Subject: FW: P1694 Shrublands Nursery, Roundstone Lane, Angmering - Application Ref. No. A/64/21/PL

I provide my comments upon the attached NTS as below.

Client's Name	Drawing Title
Sigma Homes	Proposed Elevations - Plot 1
Job Title	Scale
The Former Shrubland Nursery, Roundstone Lane, Angmering	1:100 @ A3

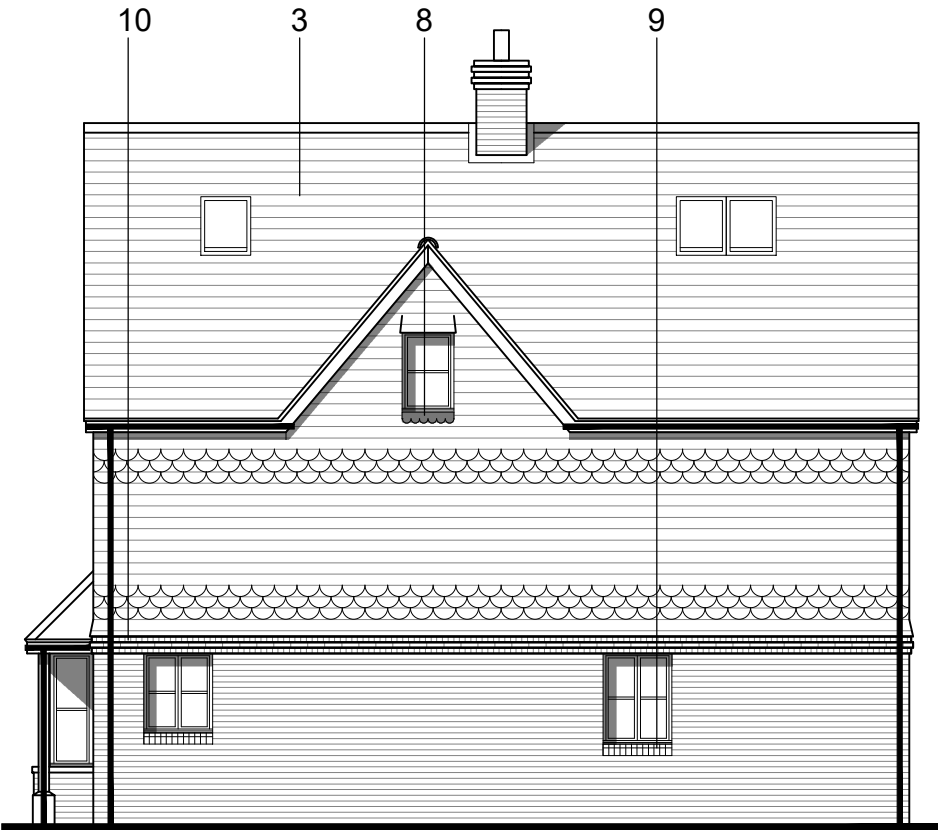
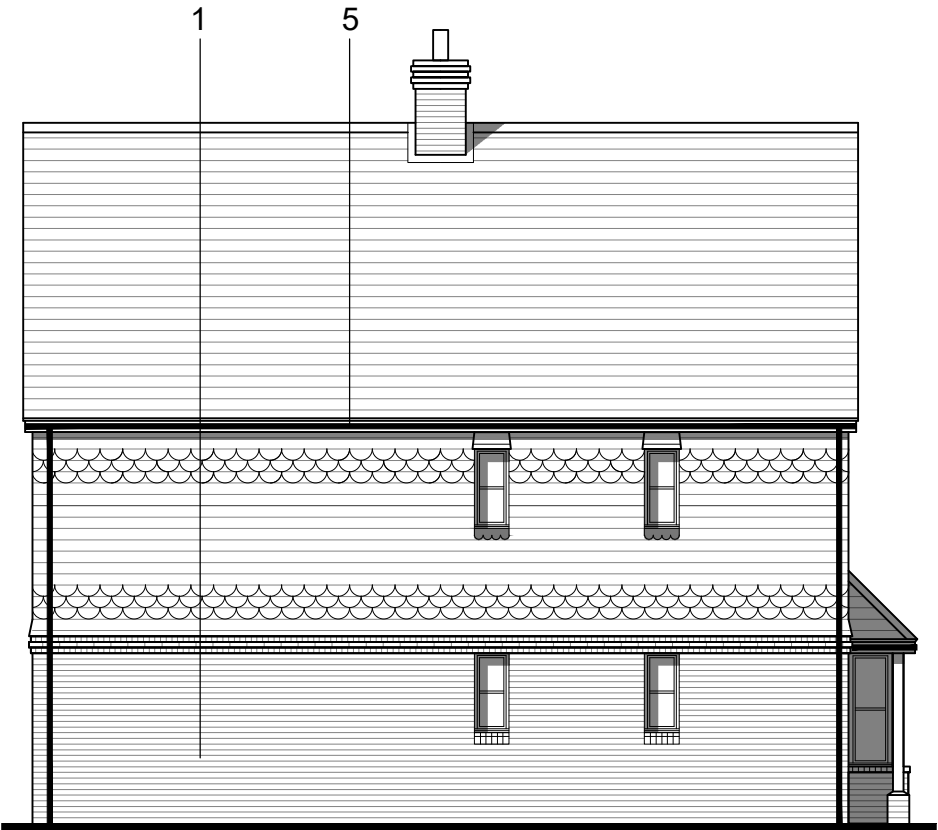
Unit/Plot 1.

*Thank you for pointing out Velux type windows to the roof bedroom. This indeed provides suitable ventilation to this space and the roof bedroom is considered acceptable in this state.

*Means of noise mitigation/ventilation will be required to the first floor bedroom alone.

Client's Name	Drawing Title
Sigma Homes	Proposed Elevations - Plots 22,23
Job Title	Scale
The Former Shrubland Nursery, Roundstone Lane, Angmering	1:100 @ A3

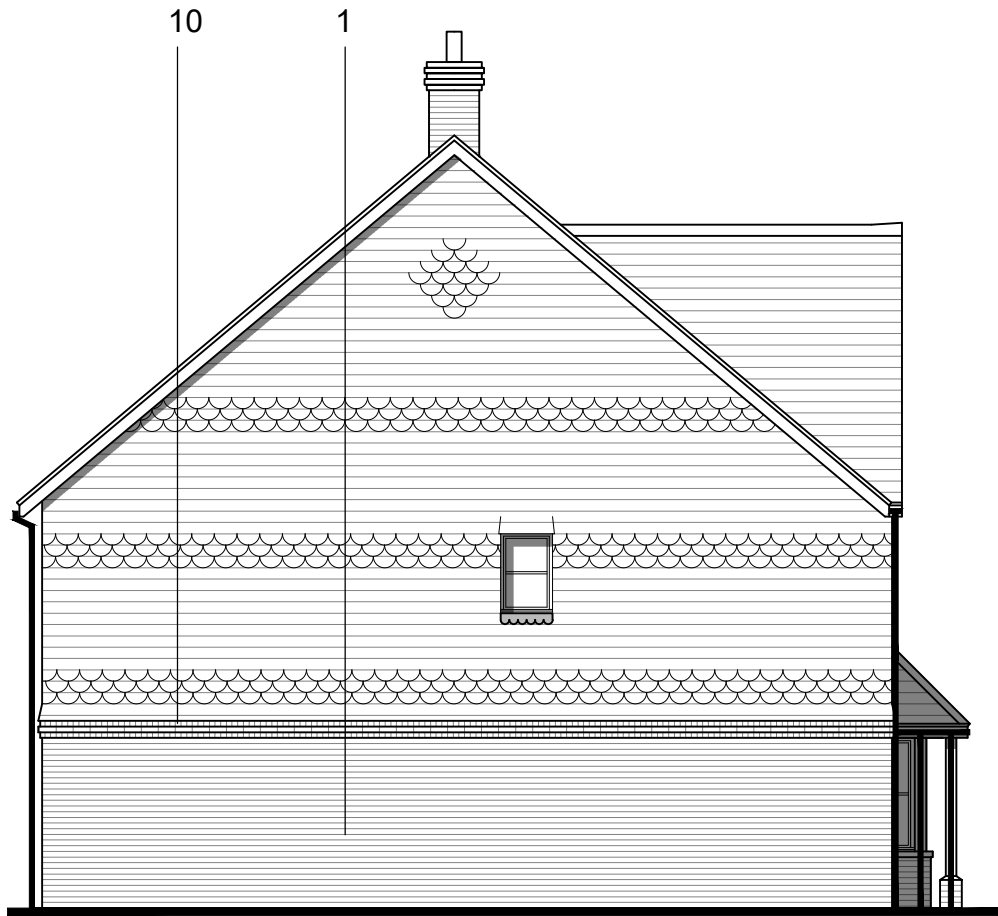
3.2.1 Plot 23 – Southern Boundary Close to Roundstone Boarding Kennels and Cattery.

*Again, highest levels of averaged noise are indicated in the early morning at 4-5am and 6-7am. I believe that the dogs are fed at 7am. Please carry out on site attended monitoring and/or recording to identify the noise source/s in this case. Nevertheless, we know that the incidence of LAMax is high. I would suggest discussion with Arun Planning Department and the Kennels' owner to determine whether a suitably high acoustic fence would be acceptable in this case, bearing in mind that the kennels site will be enclosed by a 3m acoustic fence to the west due to building of houses north of Mayflower Way A/46/19/PL.

*Plots 22 and 23 have the same internal layout and orientation as Plots 2 & 3. An acoustic fence near the kennels will be unable to mitigate unacceptable LAMax levels affecting high level bedrooms. Comments apply as for Plots 2 & 3 based upon one minute LAMax levels. Such treatment to include Plot 6.
